Ribble Valley Borough Council
Church Walk,
Clitheroe,
BB7 2RA

Phone: 0300 123 6780
Email: lhscustomerservice@lancashire.gov.uk
Your ref:
Our ref: LHS/CS/03/2017/0171 and 0173
Date: 9th August 2016

Proposal:	Change of use of existing two storey rear extension from bed and breakfast guest rooms and cafe to form one new dwelling.
Location:	Dog and Partridge Tosside BD23 4SQ
Grid Ref:	376895 - 456092

PROPOSED

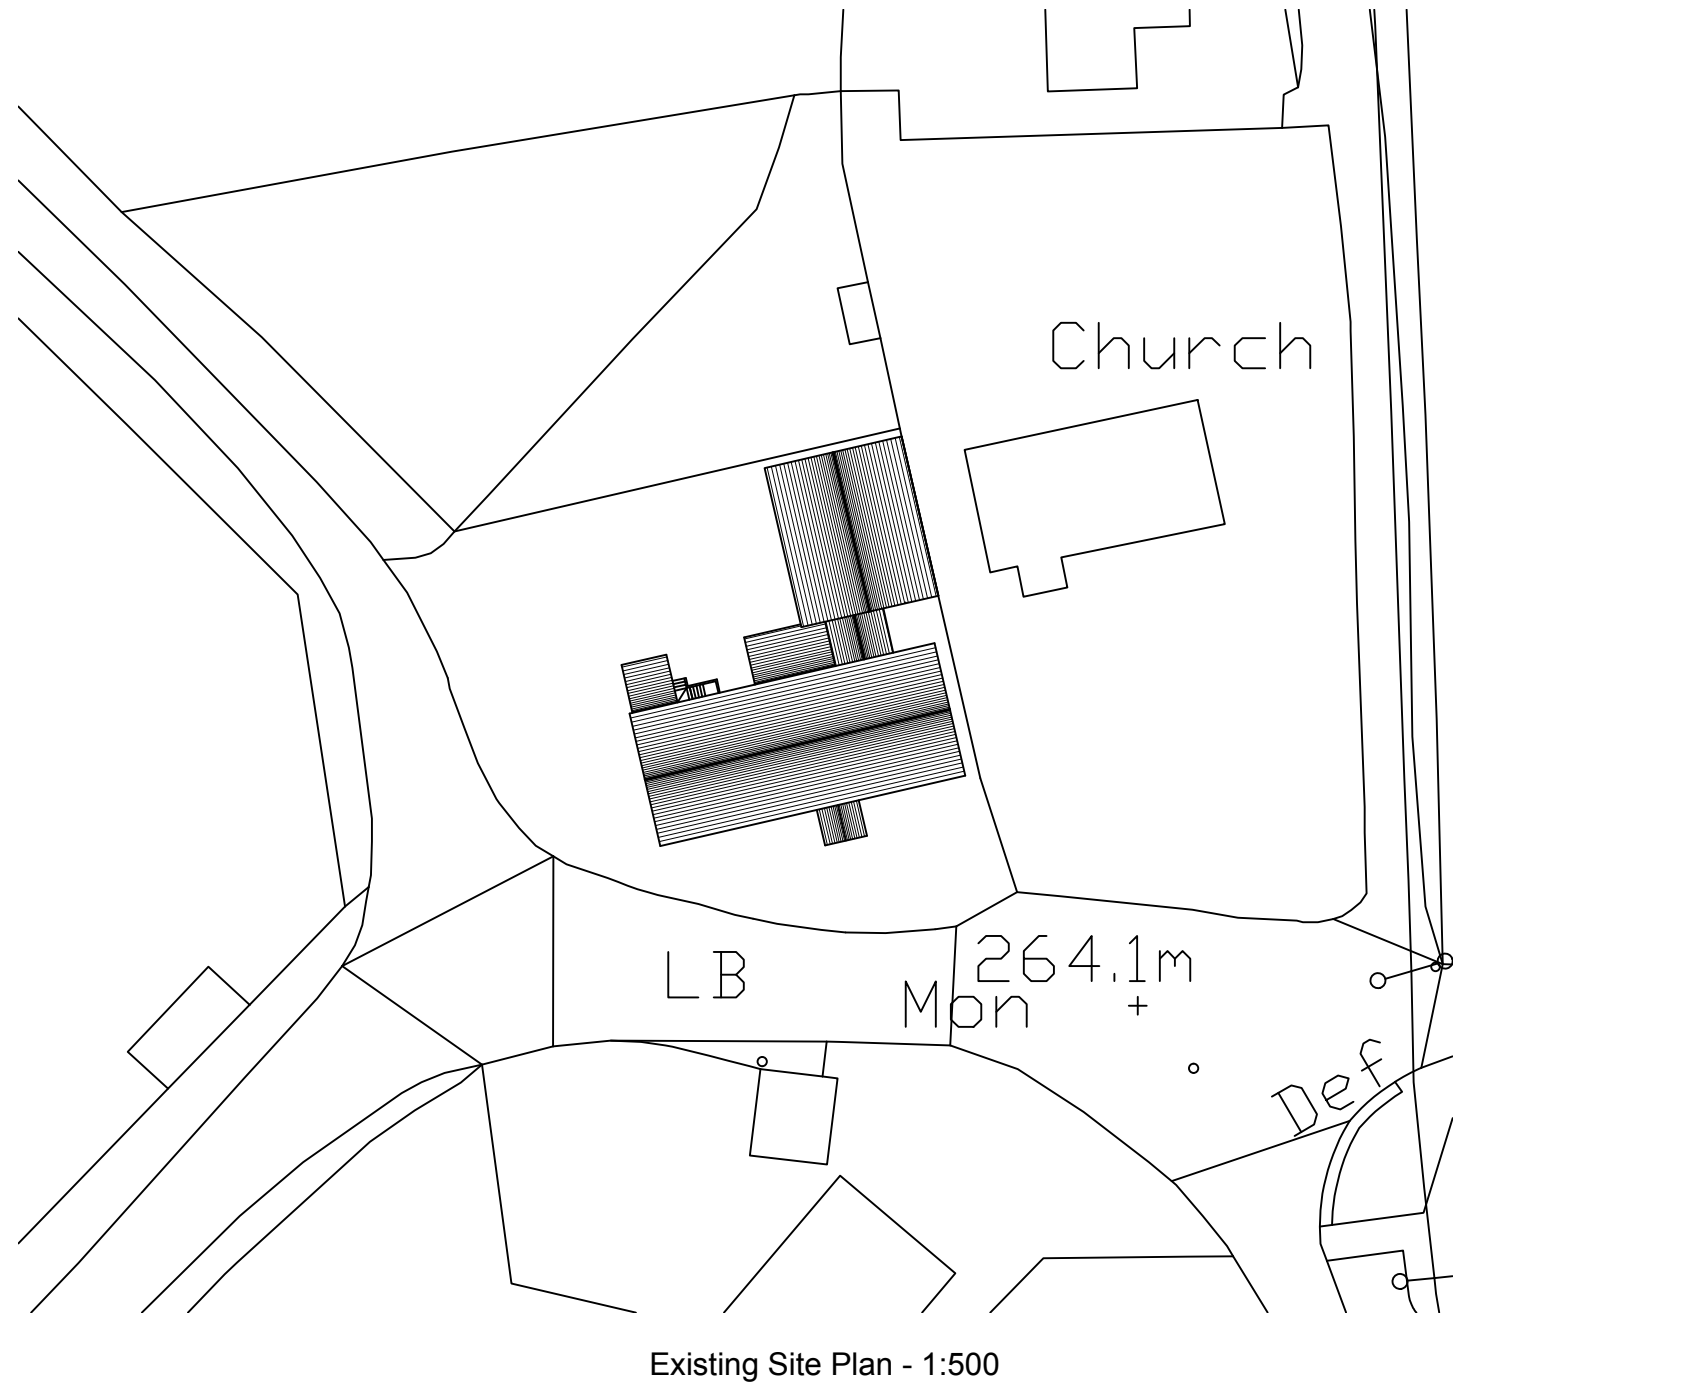
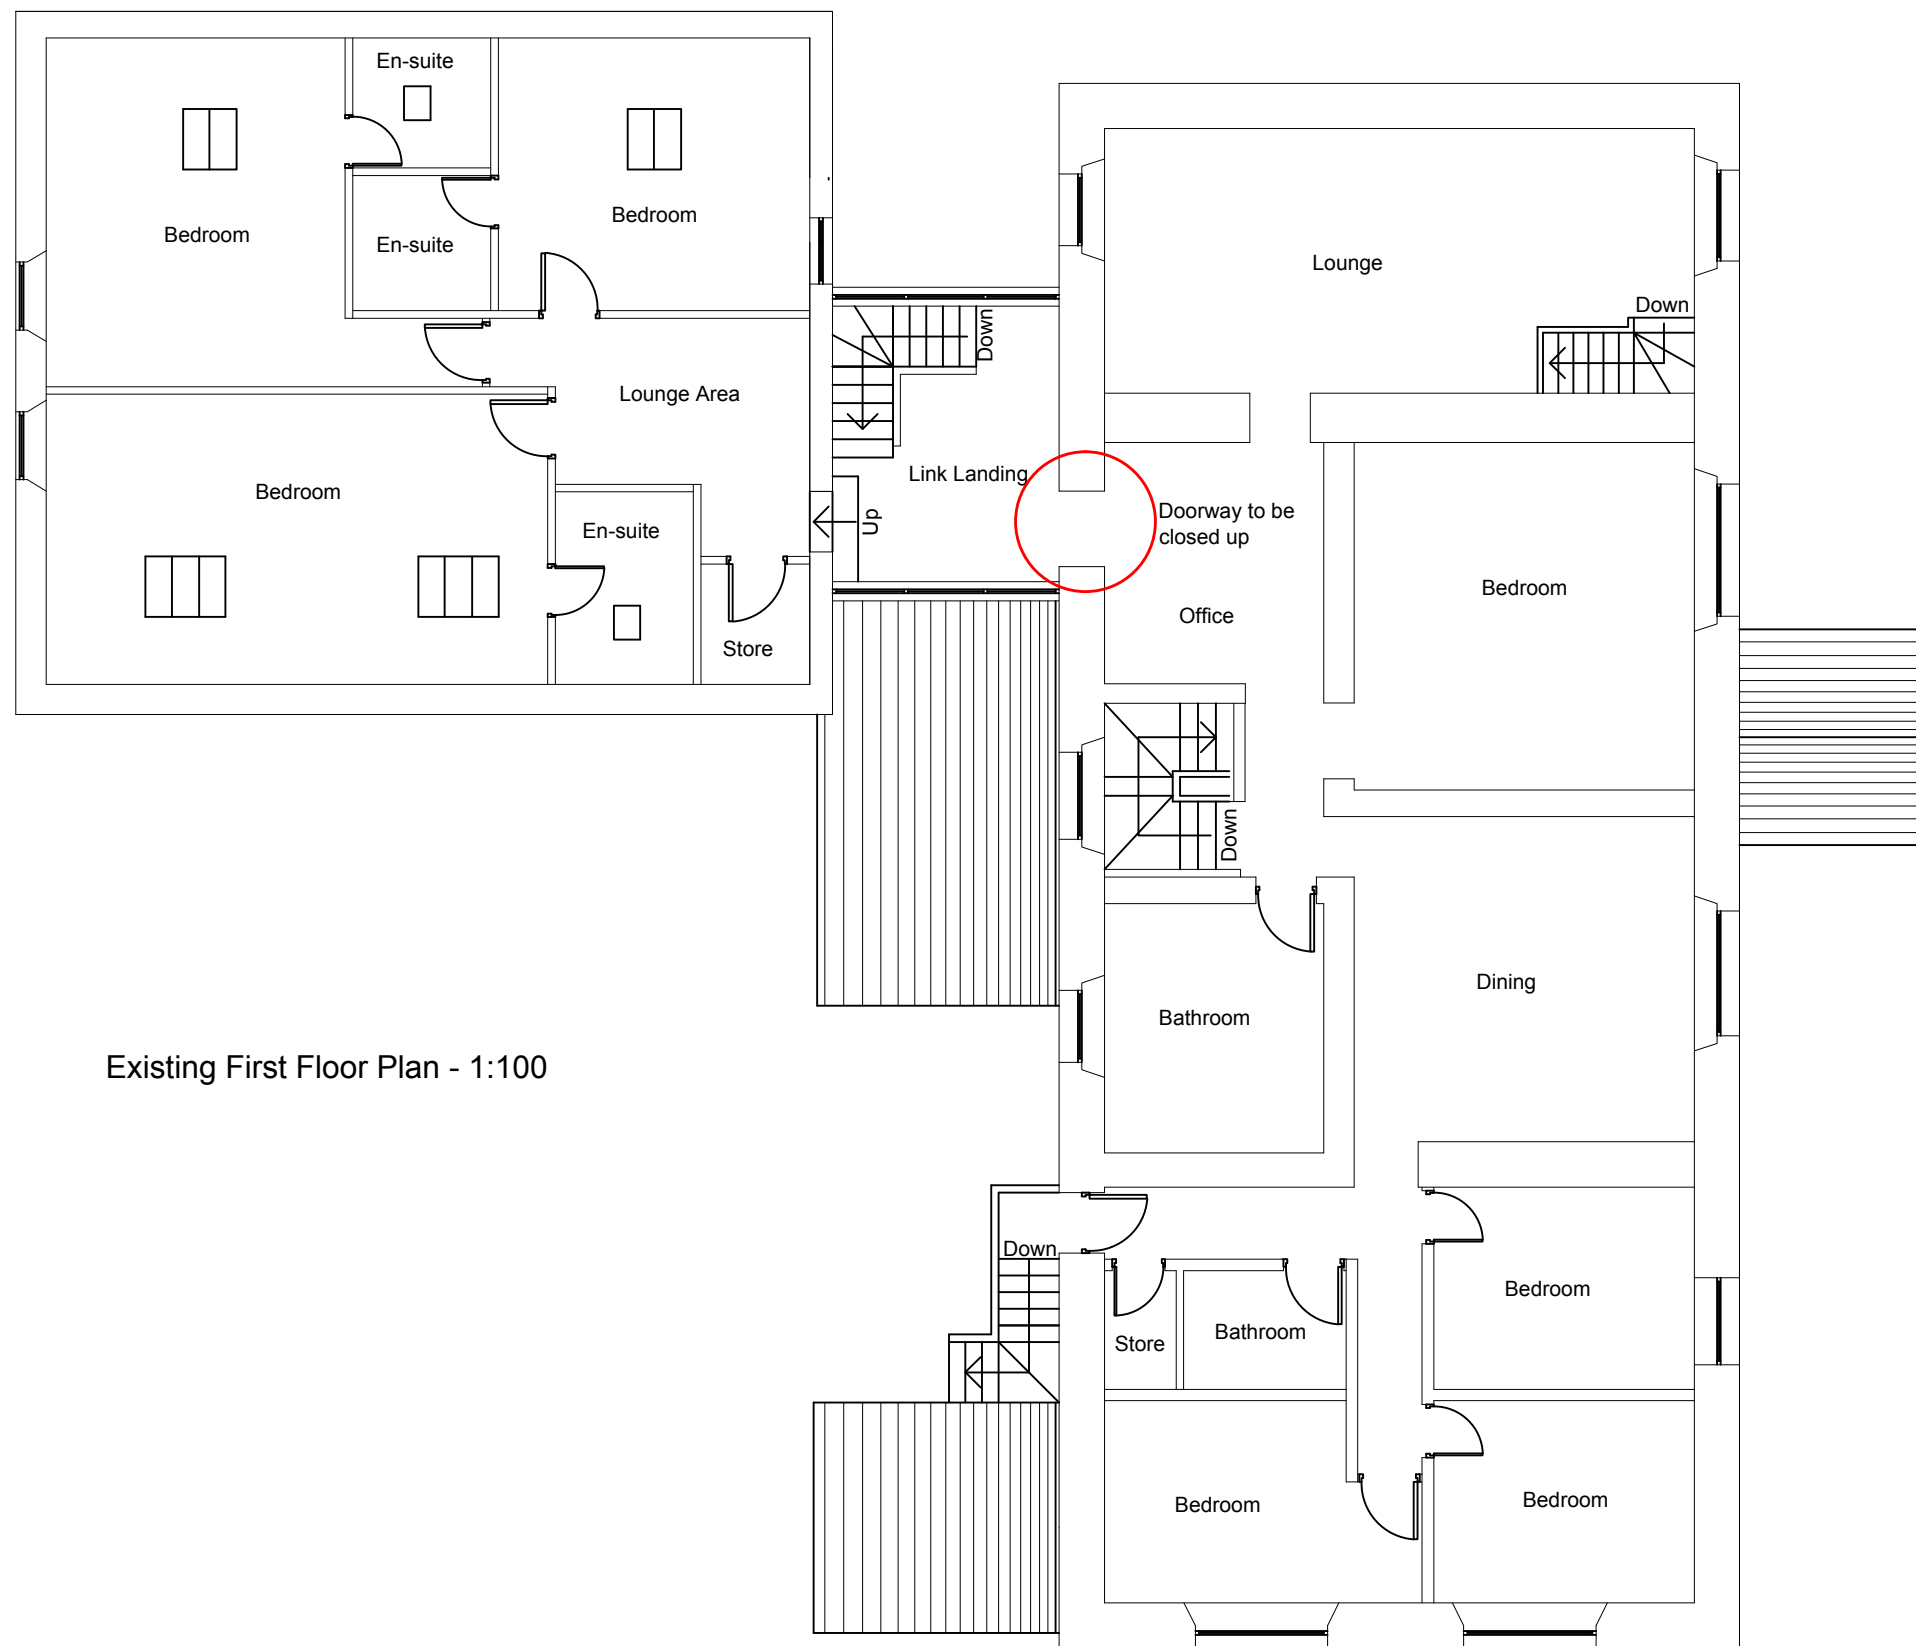
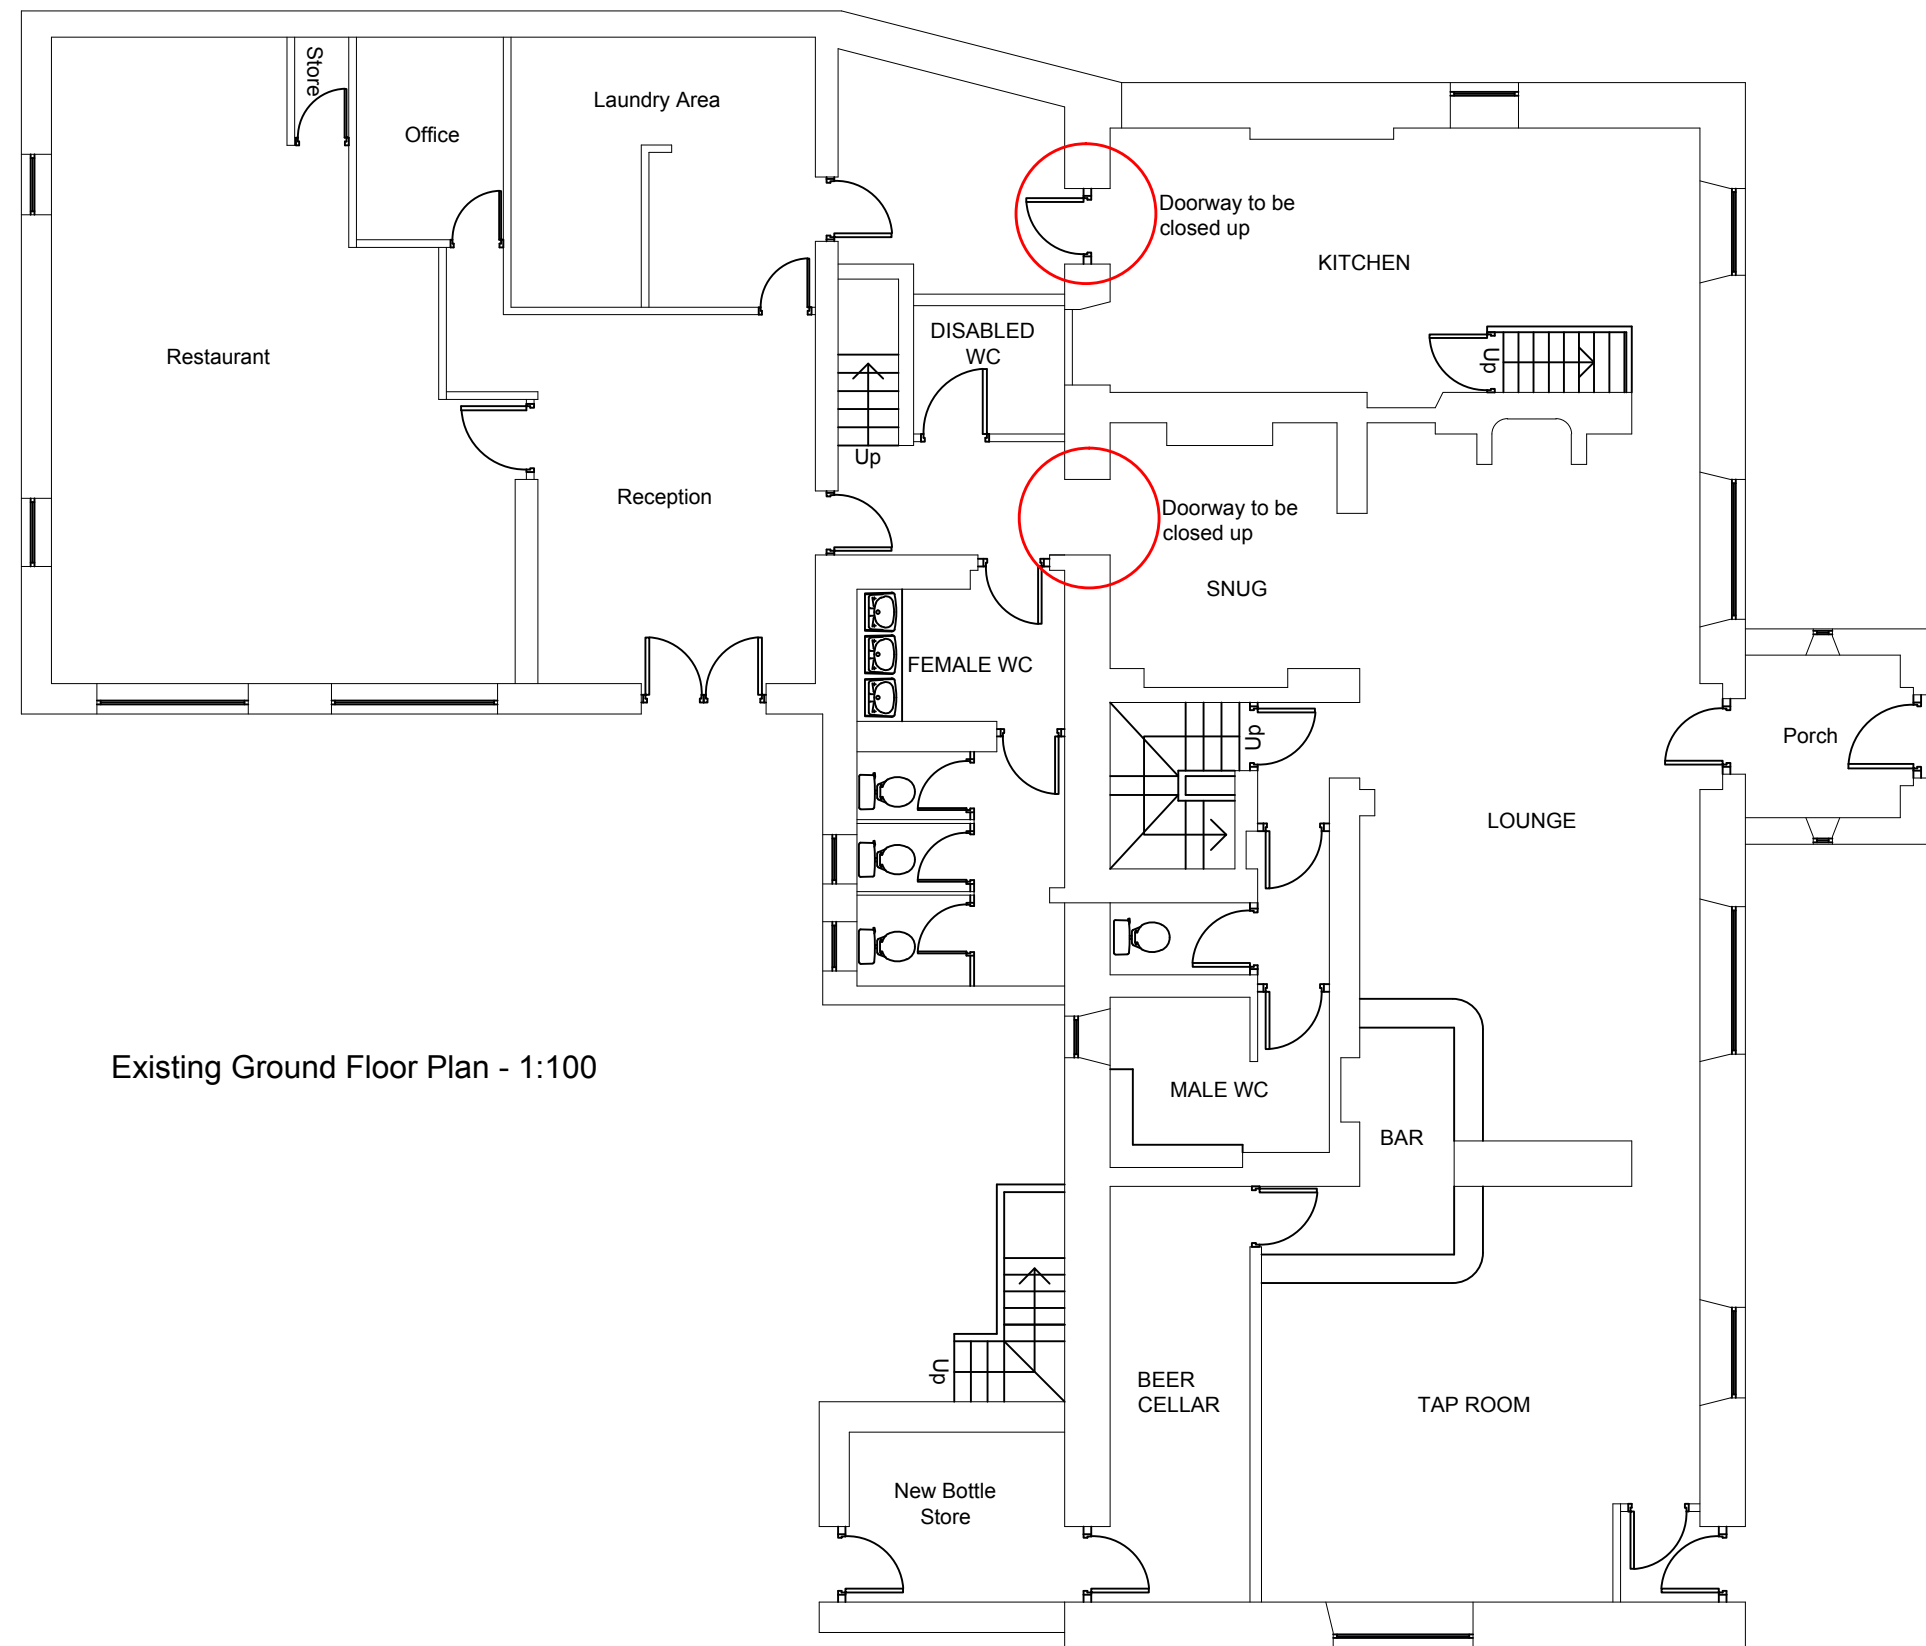
The Highway Development Control Section does not have any objections in principle to the proposed change of use providing the applicant can provide an acceptable level of off-road car parking for the remaining public house and owner's accommodation above.

Based on the car parking recommendations in the Joint Lancashire Structure Plan and the Ribble Valley Parking Standards, the Highway Development Control Section is of the opinion that the applicant should provide either one off-road car parking space for each 5sqm of public floor area for the public house or one off-road car parking space per 8sqm of the gross ground floor area.

The Highway Development Control Section is of the opinion that on road parking fronting the site would have a detrimental impact on highway safety by narrowing the available carriageway width, with no provisions for pedestrians needing to walk in the road to pass the parked vehicles. On-road parking would also prevent two way traffic movements at the detriment to highway and the obstruction of the sight lines from the Bailey Lane at the detriment to highway safety.

There is also a private access serving the properties opposite the site and on-road parked cars would affect the safe manoeuvring in and out of this drive.

The applicant is advised to provide an accurate survey of the floor areas as recommended above and then show the recommended number of parking spaces before determining the application, in the interest of highway safety.
